SEEGER HOMES INC. - SALES OFFICE

SITE DEVELOPMENT PLANS LOT 3, APPALOOSA HIGHWAY 24 SUBDIVISION

Lighting Plan_v4-redline.pdf Markup Summary

SHEET NO:
C-01

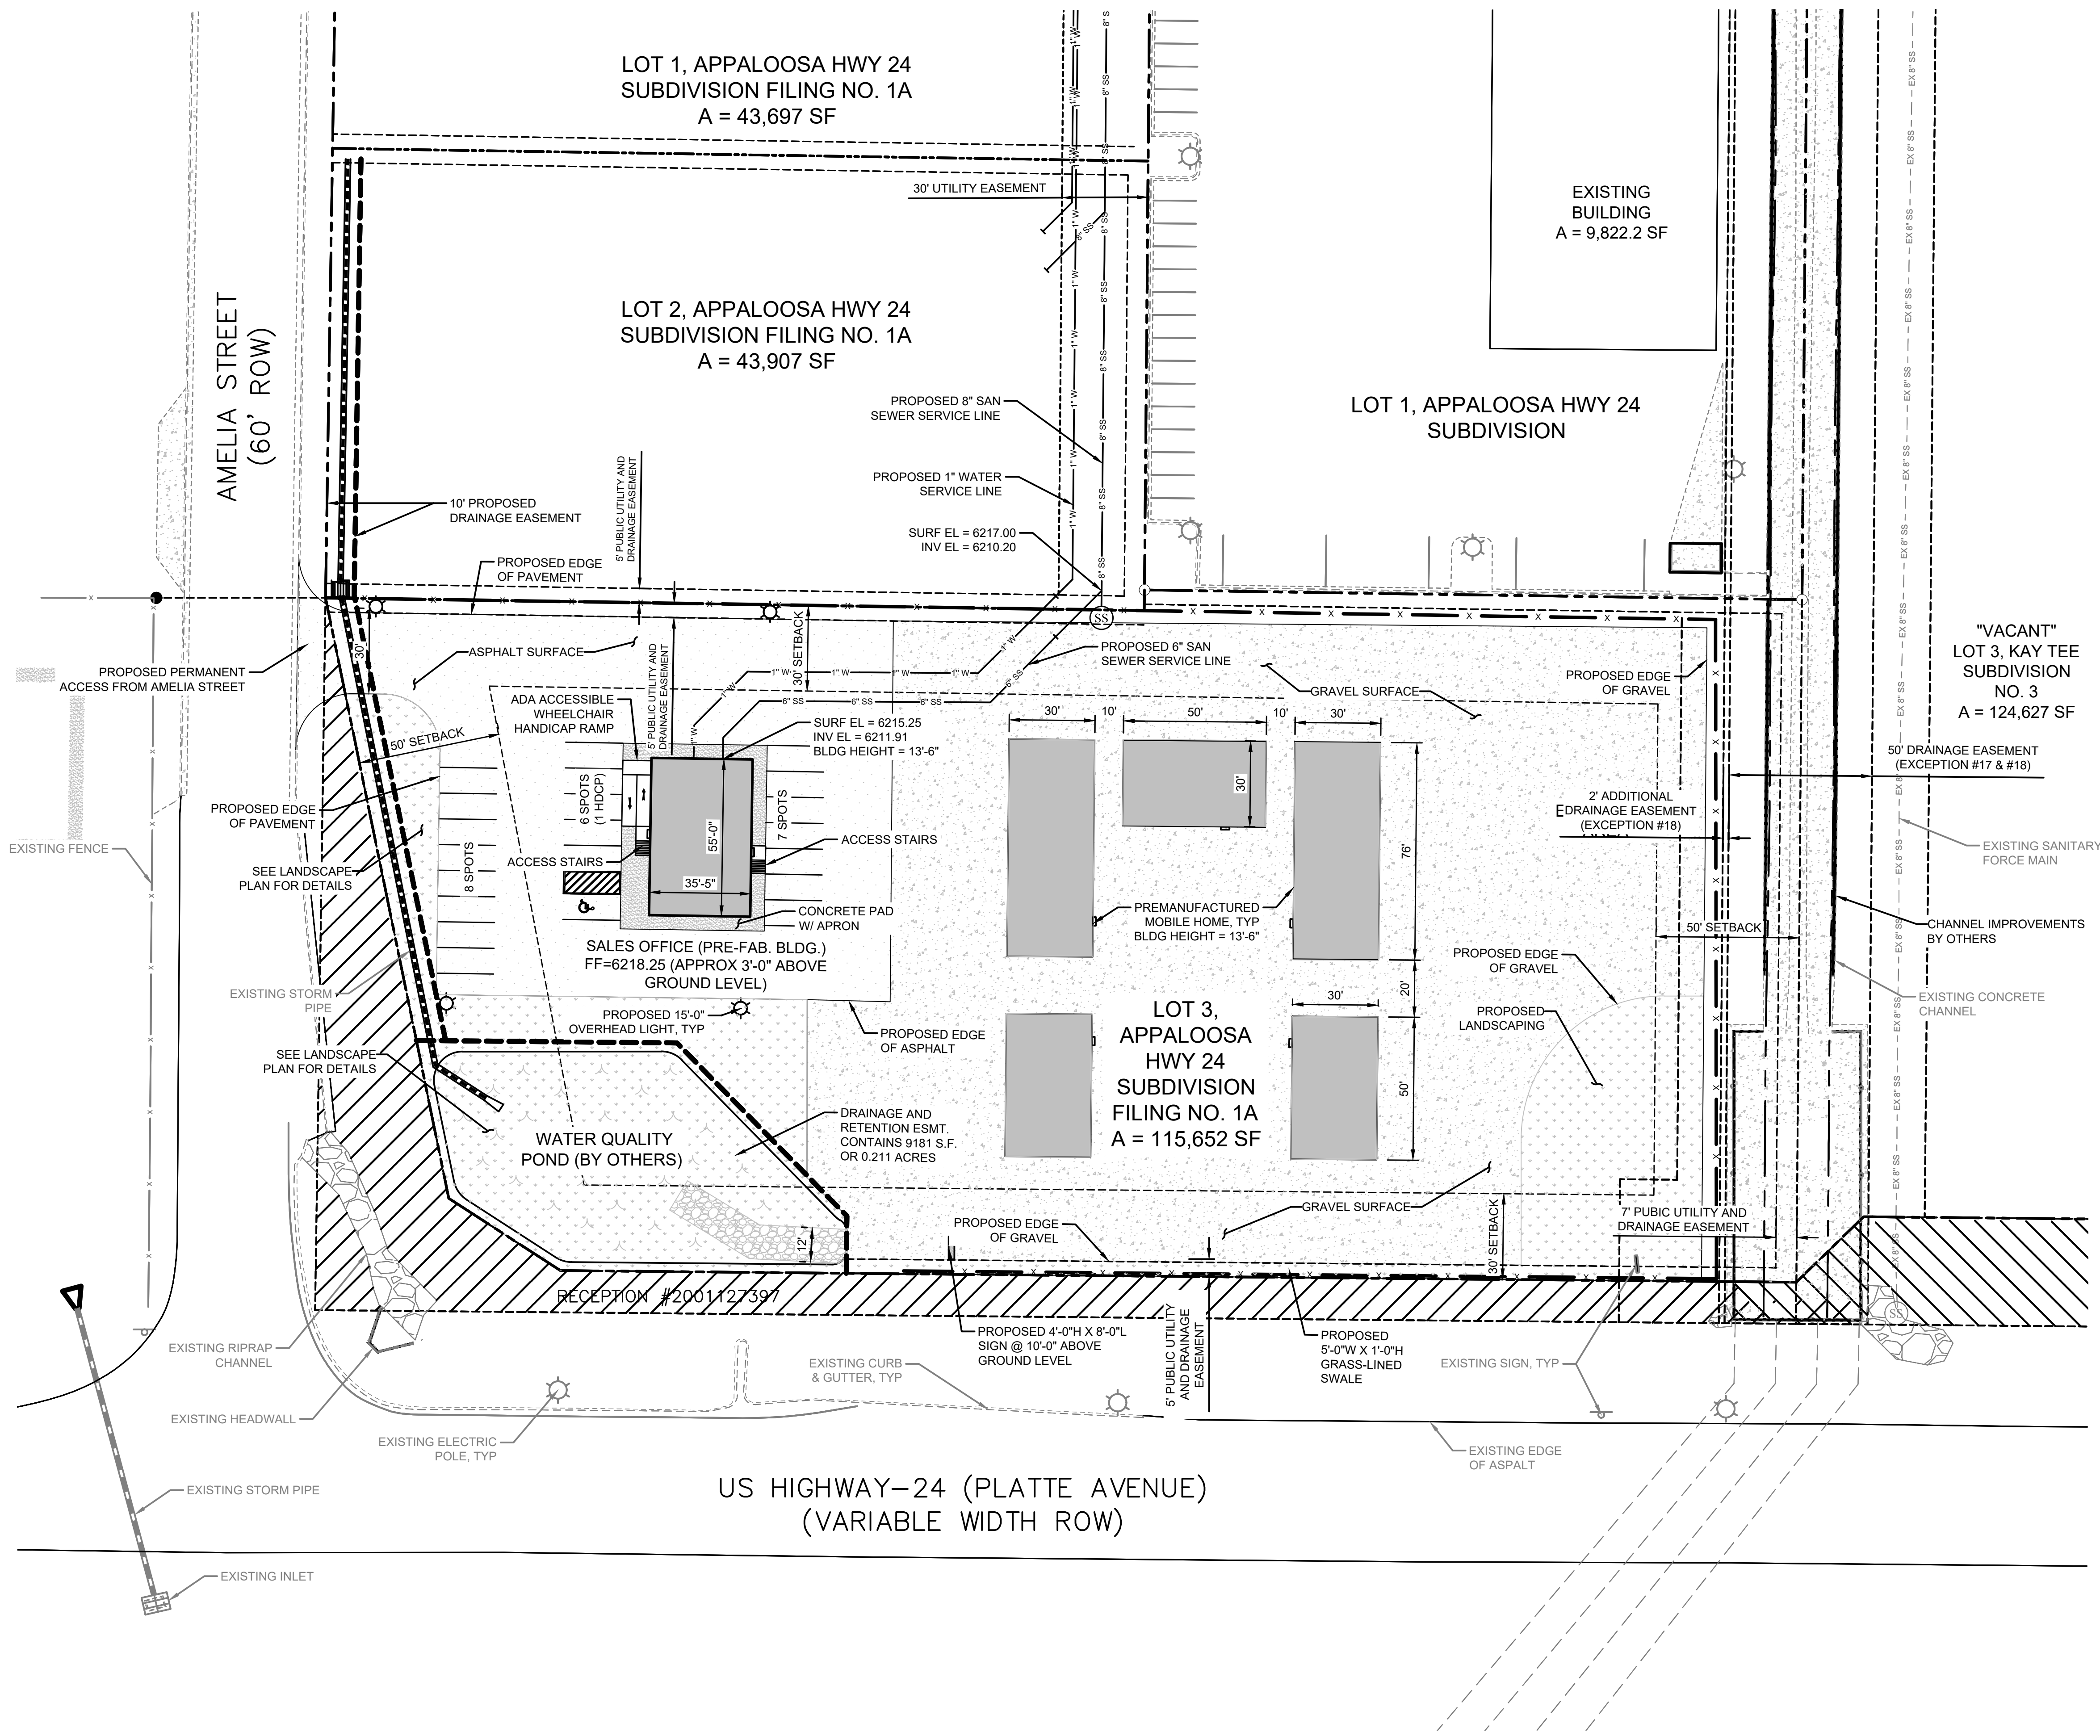
Subject: Callout
Page Label: [1] C-01
Lock: Unlocked
Author: dsdkendall
Date: 7/18/2019 9:27:49 AM
Status:
Color: 
Layer:
Space:

1A
